Phone: (01772) 531734
Fax:
Email: douglas.moir@lancashire.gov.uk
Your ref:
Our ref: ASM/ASP/DM
Date: 6 September 2012

PROPOSED: Conversion of barn and outbuildings into 2no. dwellings, incorporating new garden room, entrance extension and package treatment plant. Bailey Hall Barn, Hurst Green (3/2012/0602 & 0608)

Doug Moir
Planning Officer (Archaeology)

As Proposed
Repair and Alterations

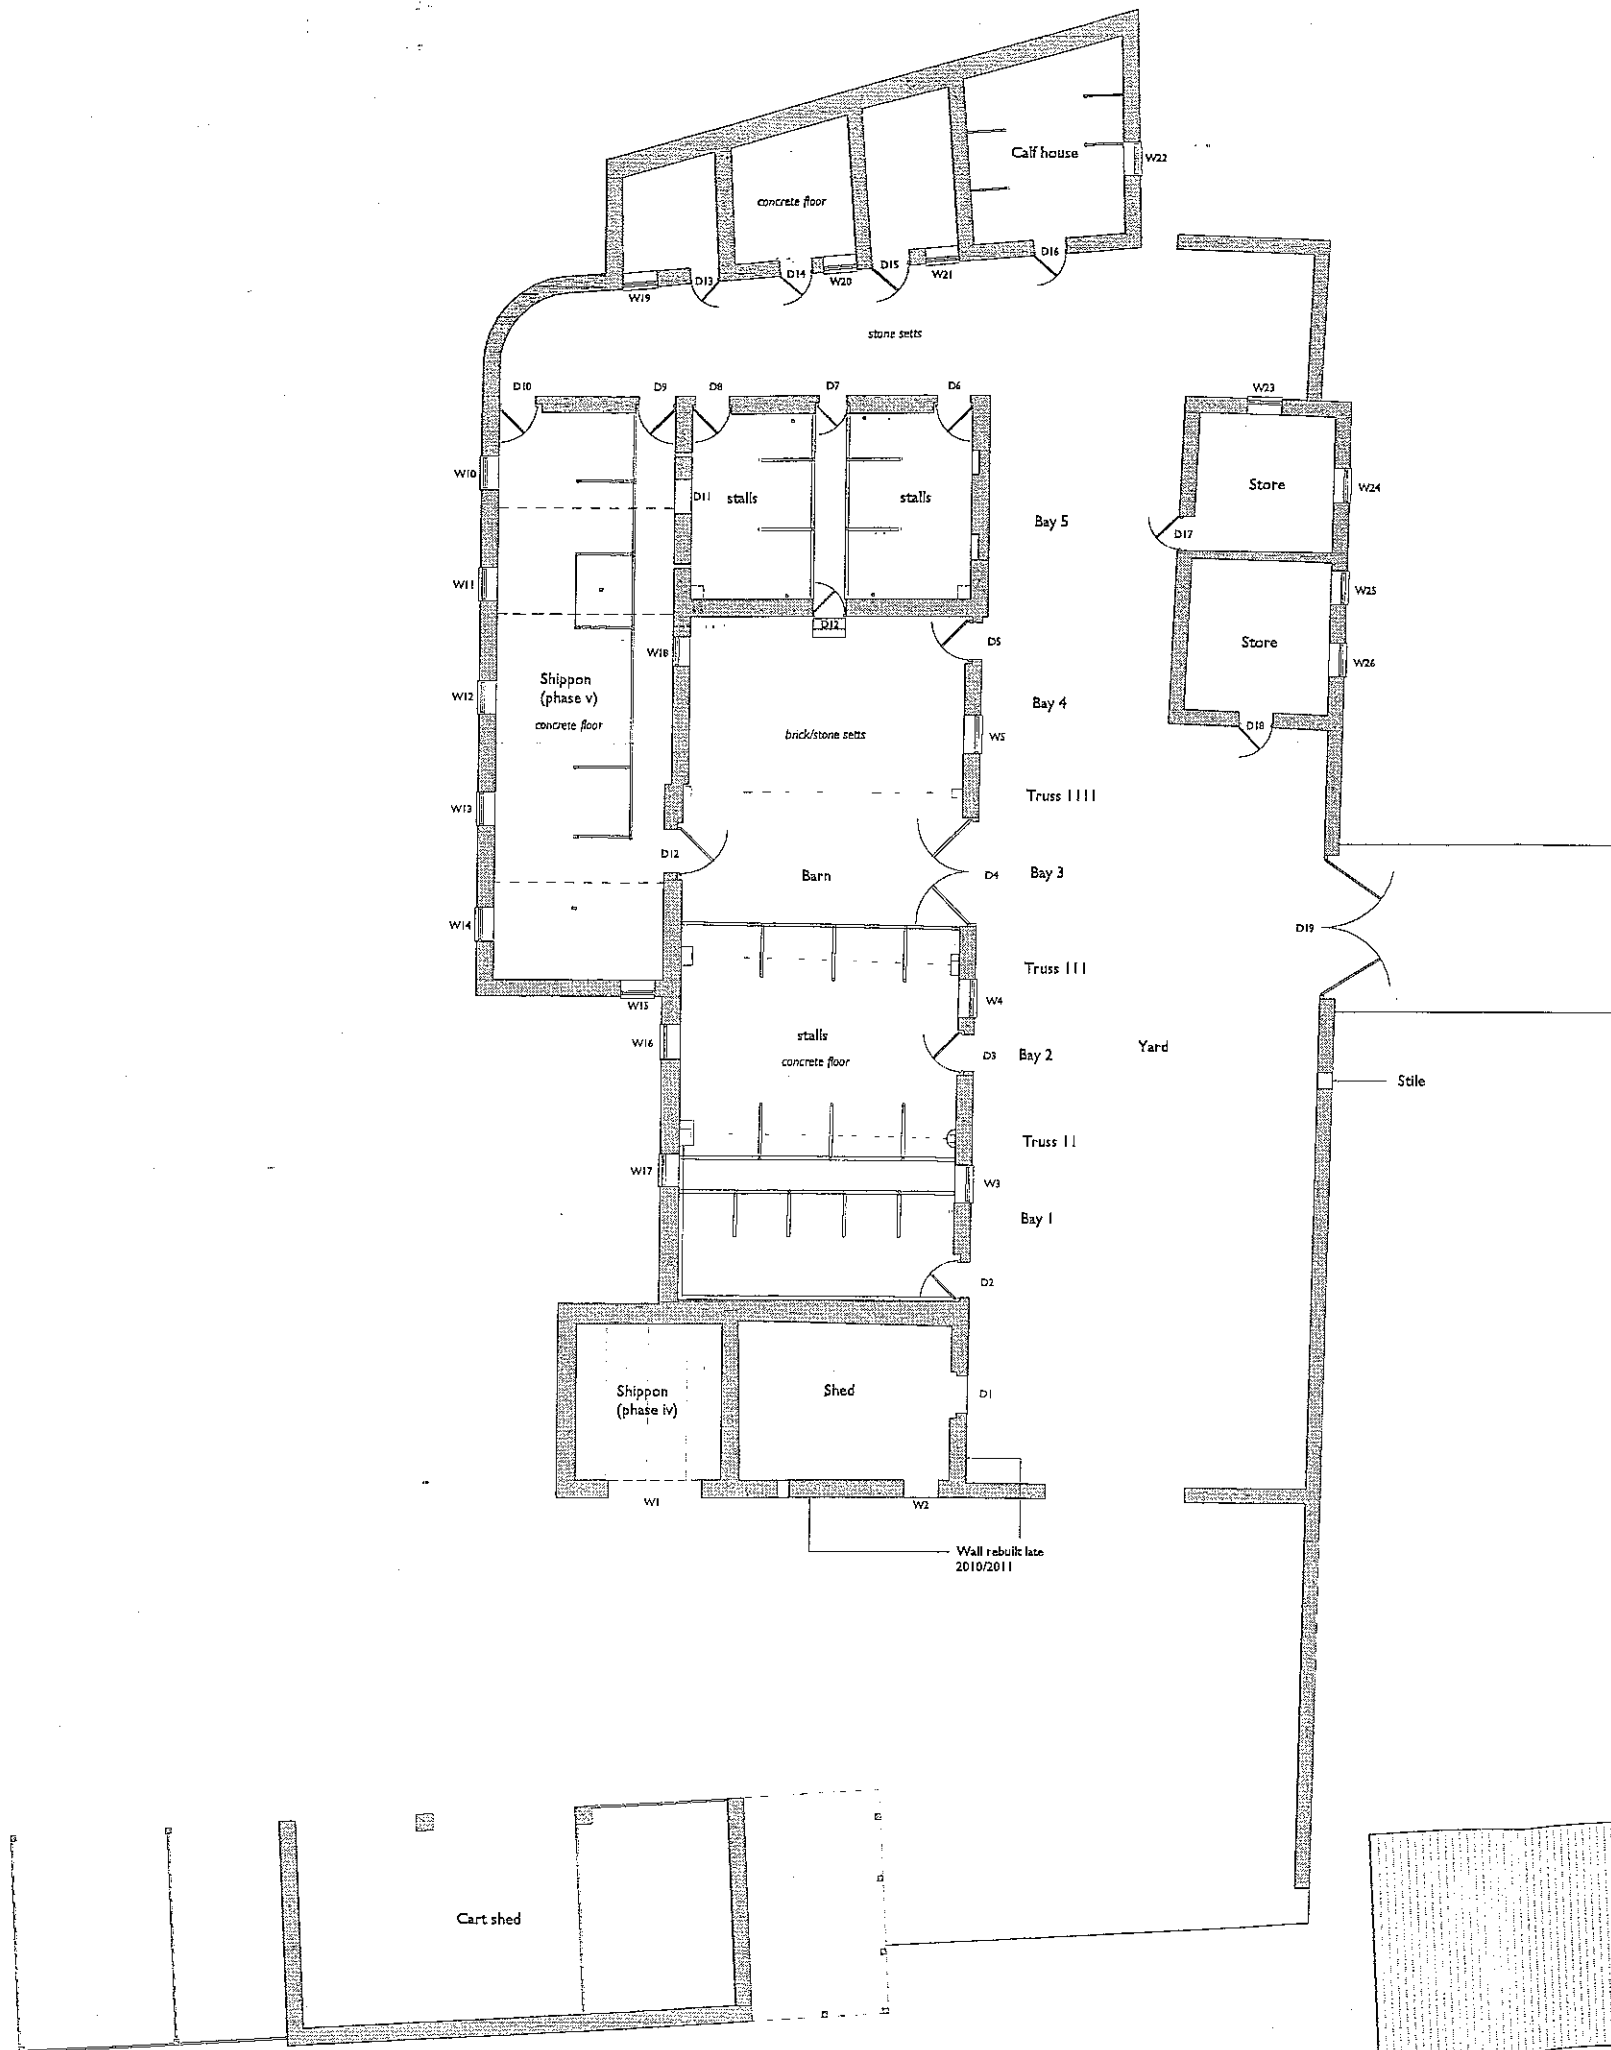
The Conversion Assessment that accompanies the application makes reference to works to repair/strengthen the roof structure in accordance with the Structural Engineer's appraisal. Although the general thrust of the application is one of minimal intervention with the timber frame, the admission in section 2.4 of the appraisal that the rafters could not be closely inspected and there was evidence for rot, LCAS is of the opinion that the Borough Council does not have sufficient information to address the requirements of NPPF para. 132.

It is felt that a more definitive statement on the exact nature and location of repairs needs to be submitted, in the form of a detailed annotated drawing of the timber frame, and that in this instance a detailed archaeological record of the frame would be therefore be appropriate. Such a record would include details such as individual joints, peg hole arrangement and any tool marks and carpenters marks, which as well as providing a permanent record of the structure, could also be used for the production of a survey indicating proposed areas of repair and replacement and to indicate the sample locations of the dendrochronological survey.
